Our Reference: SYD12/00433
Your Reference: SSD 5036-2011
Contact: Ravi Raveendra
Telephone: 8849 2540

**EXHIBITION OF ENVIRONMENTAL IMPACT STATEMENT FOR A STATE
SIGNIFICANT DEVELOPMENT APPLICATION FOR STAGE 1 DEVELOPMENT
OF A COMPREHENSIVE CANCER CARE AND BLOOD DISORDER CENTRE AT
THE PRINCE OF WALES HOSPITAL SITE, RANDWICK (SSD 5036-2011)**

**Land Use Planning and Assessment Manager
Transport Planning Section, Roads & Maritime Services**

Figure B1 – Medium Rigid Truck movement at Gate No 6 and inside the car park south of the Heritage Gate

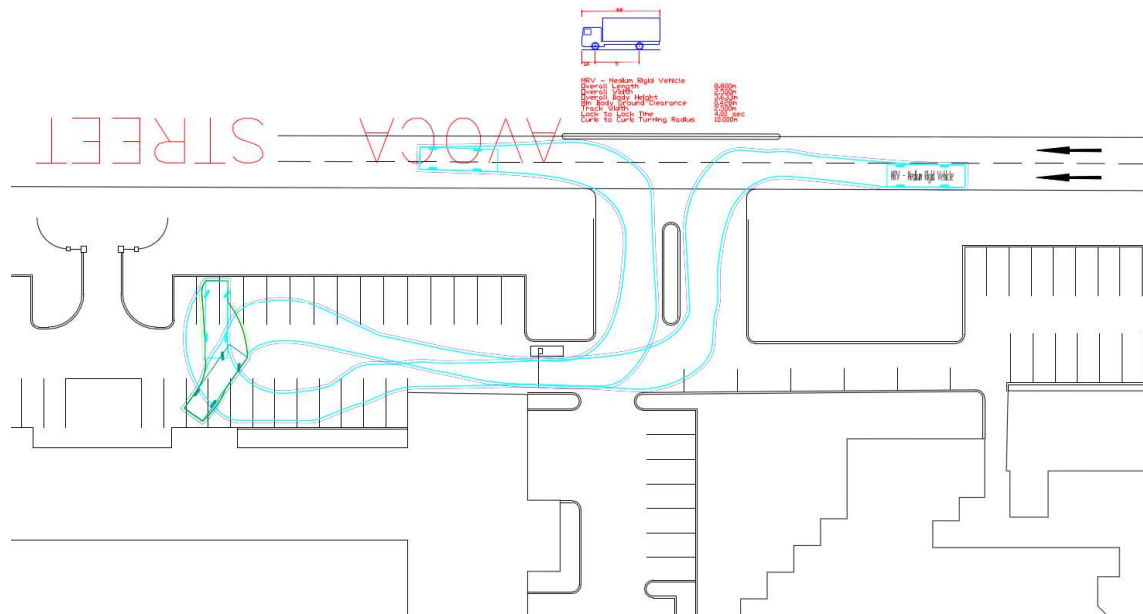
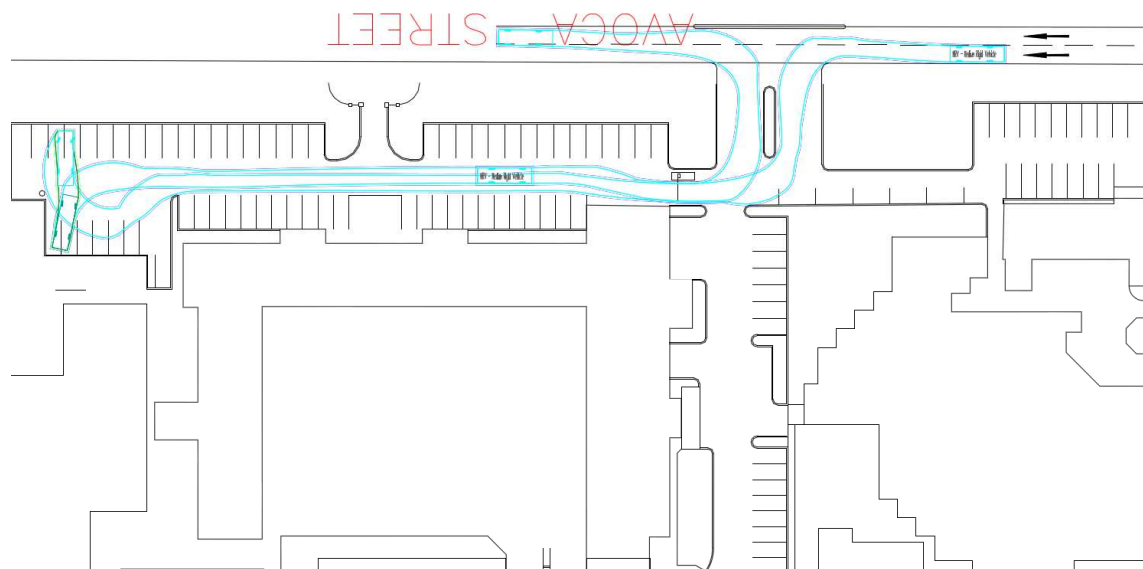
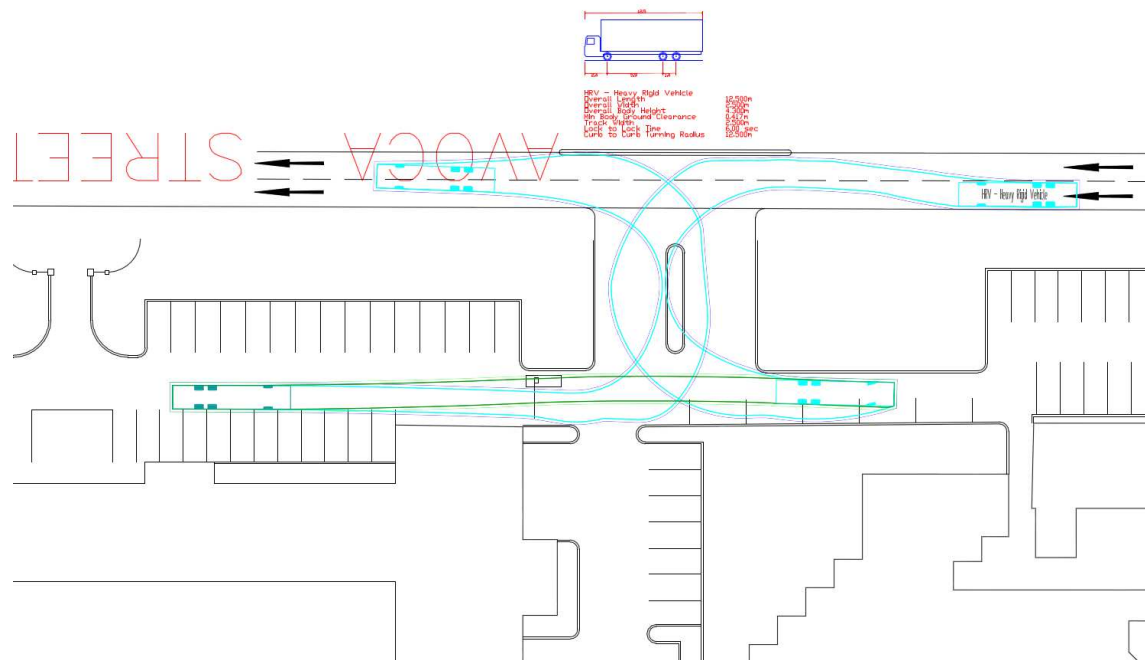
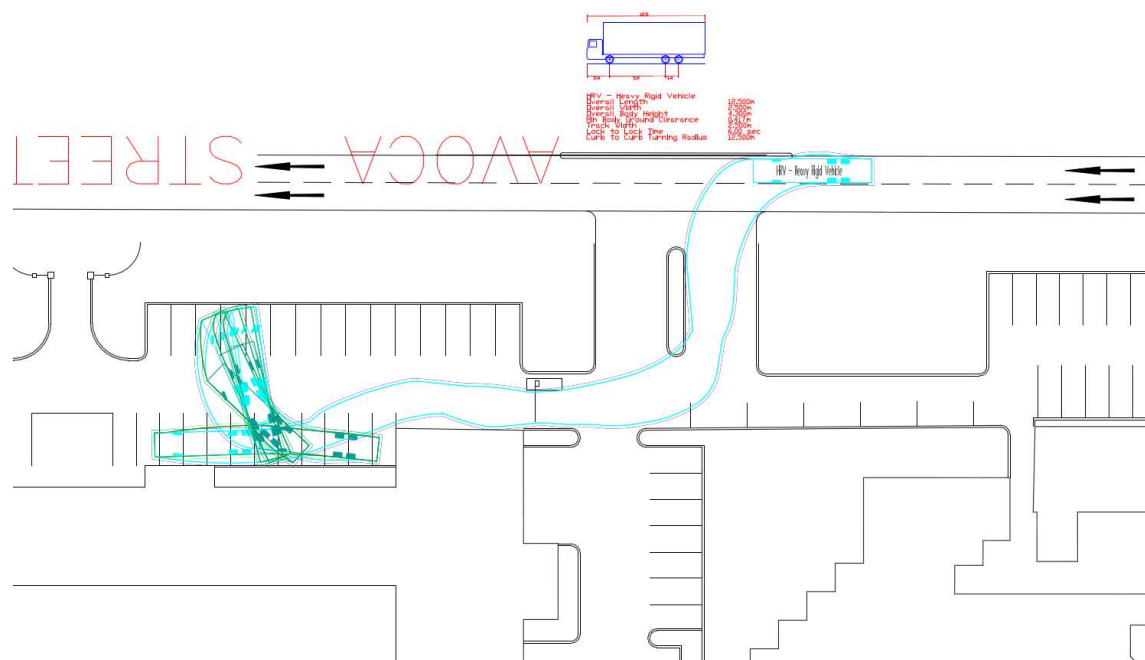
11. During construction it is noted that conflict will exist between vehicular traffic and pedestrian at Gate No. 6. Measures need to be implemented to minimise the potential of crashes occurring. Similarly the re-direction of pedestrians to other areas needs to be examined for the provision of appropriate infrastructure to cater for their movement.
